Our Case Number: ABP-319866-24

Re: Proposed development known as North Irish Sea Array ("NISA") Offshore Wind Farm
Located off the coast of Counties Dublin, Meath and Louth (www.northirishsearraysid.ie)

RE: APPLICATION TO AN BORD PLEAN6LA UNDER SECTION 291 OF THE PLANNING AND DEVELOPMENT ACT 2000 (AS AMENDED) FOR PERMISSION FOR NORTH IRISH SEA ARRAY (NISA)

Observation 1 – In relation to Search and Rescue and other issues for consideration in relation to response emergency preparedness for Layout Option 1 & Option 2

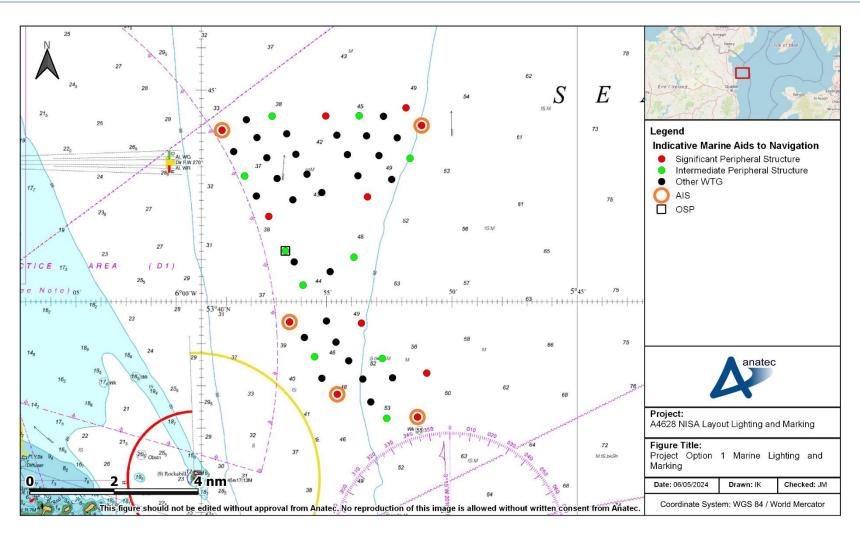
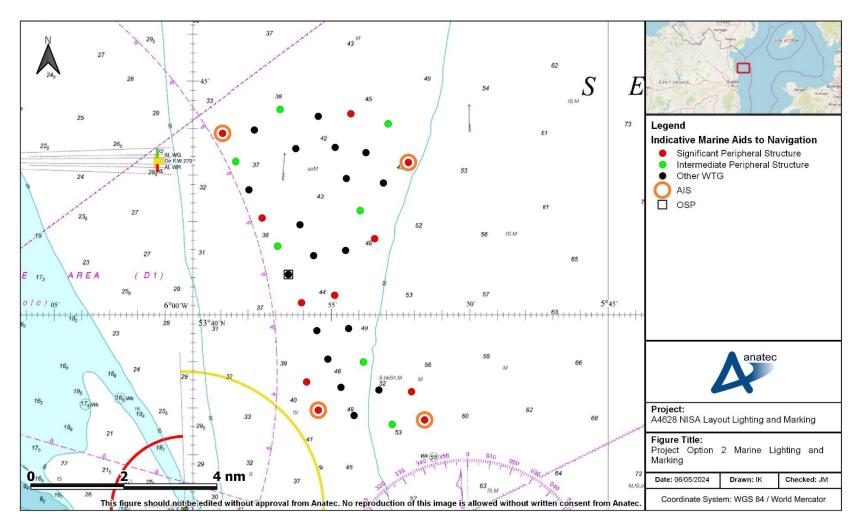
The Irish Coast Guard has concerns in relation to carrying out Search & Rescue in the two proposed layouts (Option 1 & Option 2). IRCG requests that both layouts should be further revised, in line with search & rescue guidelines.

1. The final positioning of the Wind Turbine Generators (WTG) is unclear because there is Limit of Deviation of 500 metres for each WTG. The proposed layouts could change significantly which will impact Search & Rescue and Emergency Response. Irish Coast Guard are unable to guarantee that search and rescue operations can be carried out safely because the final position of all WTGs is unknown at this time.

2. The layouts only have one consistent line of orientation. No justification was provided to IRCG in prior consultation on using one line of orientation. IRCG request developers should start with a layout option with at least two consistent lines of orientation. The layout of a wind farm or other ORED should also be as regular as possible e.g. a grid pattern, and take into consideration any lateral movement of floating devices. This regularity will also benefit the safer navigation of surface rescue craft or helicopters both within and outside a wind farm. Developers are urged to communicate their proposal to the IRCG as early as possible. Regarding SAR access to windfarms, a SAR helicopter should be able to fly from one side of a windfarm to the other, or Helicopter Refuge Area in the case of larger layouts.

3. The site is irregular design. IRCG request that the layout is as regular as possible e.g. a grid pattern. Turbines are positioned together in the North and South of the development with large gaps in-between. The layout could change significantly given the 500-metre limit of deviation for each turbine.

4. The layout design is non-linear. A 'non-linear' or 'non-uniform' layout is one where there are no or few consistent lines of orientation, i.e. 'straight' rows and/or columns of turbines on at least two axes through, and on the periphery of, a windfarm. Search patterns used by the IRCG are in accordance with international standard practice contained in the International Aviation and Maritime SAR Manual (IAMSAR). All search patterns are essentially linear in that they are composed of patterns of (normally parallel) straight lines to ensure that a search-area is covered to a consistent 'coverage factor'. Therefore, non-linear ORED layouts may not necessarily provide an effective and 'safe' search-unit environment for SAR resources, or for when SAR helicopters have to operate at low altitude e.g. because straight-line paths cannot be flown without encountering physical obstacles on a desired track. This also degrades the effectiveness of a search due to crews needing to focus more of their

5. The proposed Search & Rescue (SAR) Access Lanes could be ineffective and unusable for SAR because turbine positions could change by up to 500 metres from the positions in the planning application. SAR access lanes should be a minimum of 500 metres in width. If weather conditions are such that a SAR helicopter has to fly under Instrument Meteorological Conditions (IMC) flight rules, using instrument navigation techniques and electronic systems, the aircraft will not be able to enter any wind turbine lane that is less than 500 metres wide (measured between blade tips, that are transverse to the turbine lanes, unless the blades can be rotated away from the lane to increase the spacing to 500 metres or more). The overall shape, size and geographical coverage of a wind farm, and any proximity to other wind farms, there shall be no Offshore Renewable Energy Installations, or other structures, in the wind farm or on the boundary that present an obstacle or risk to SAR helicopters flying along SAR access lanes.

1. The wind farm layout should be agreed with Irish Coast Guard prior to starting construction given the possibility of turbine locations changing by up to 500 metres and any other unforeseen circumstances.
